From: Planning
Sent: 16 January 2020 16:19
To: DC Support
Subject: FW: Great Wolf - Arboriculture

Reviewing the Arboricultural Impact assessment from desk based assessment.

© WSP UK Ltd

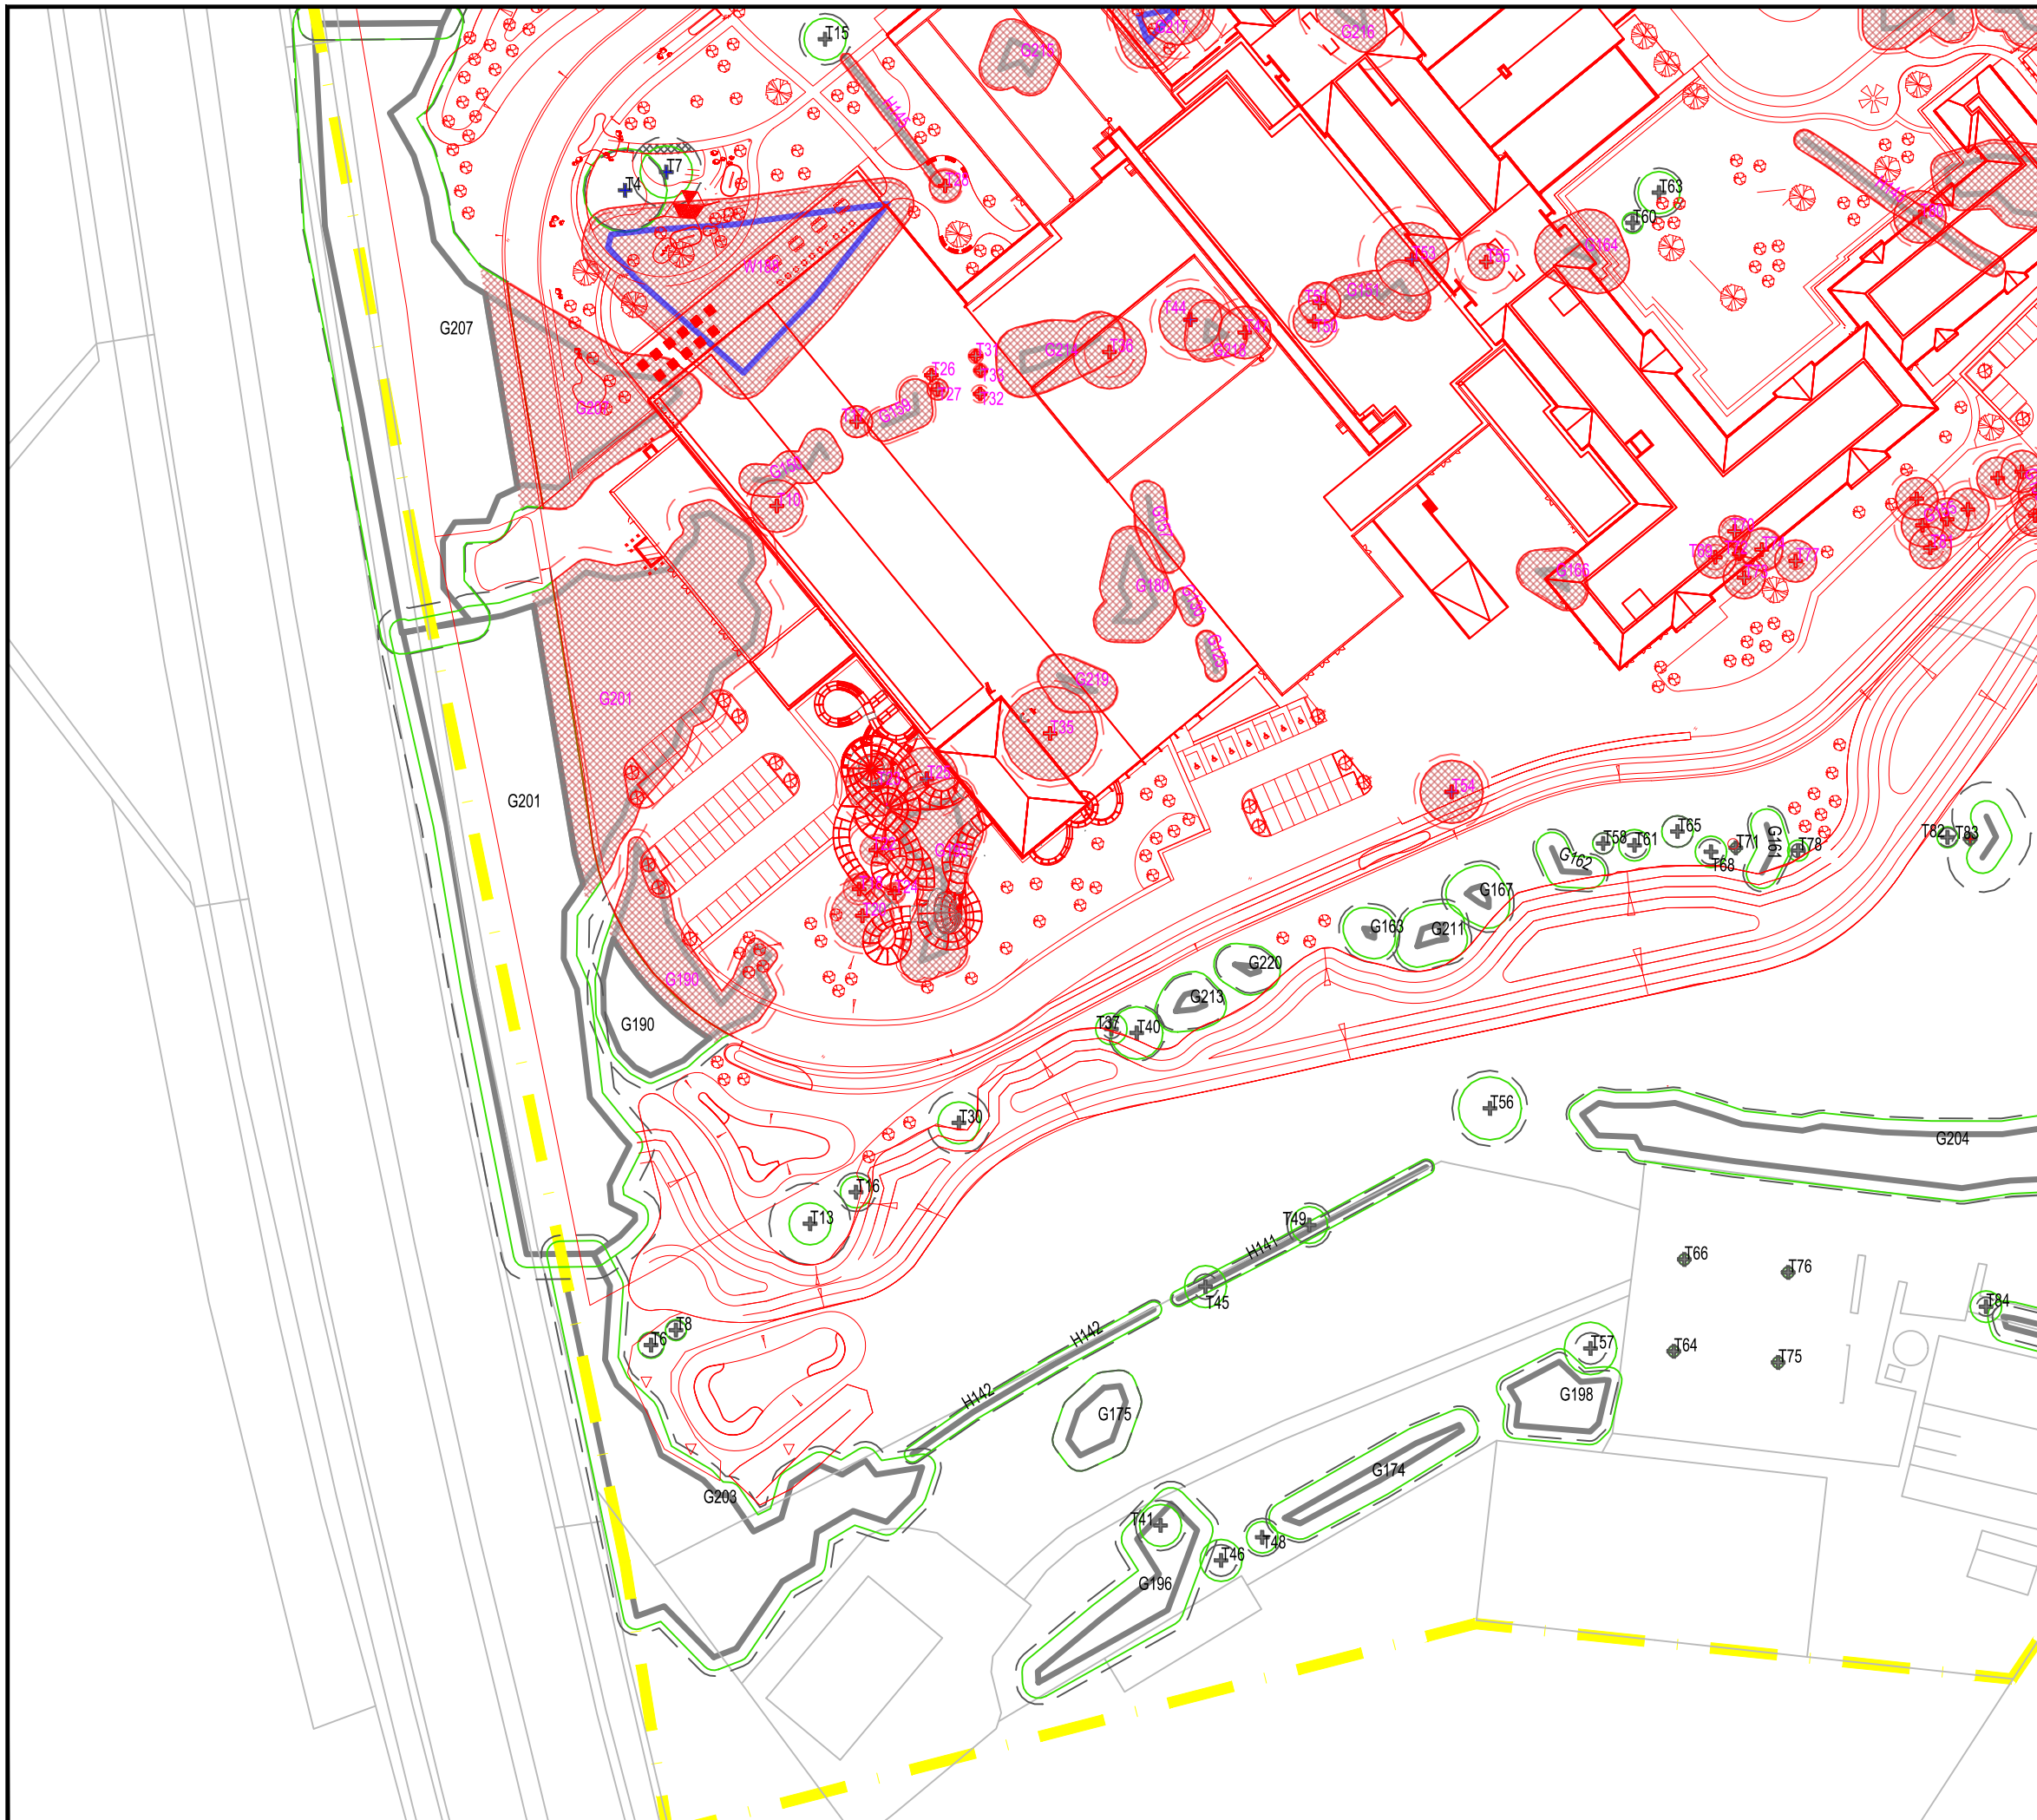
Retained trees appear to have been considered, and appropriate protective measures demonstrated. TPO no.1 1991 will require review, however in principle it is accepted the condition of the trees included in 1991 are likely to have changed, therefore their appropriateness for continued protection may also require review.
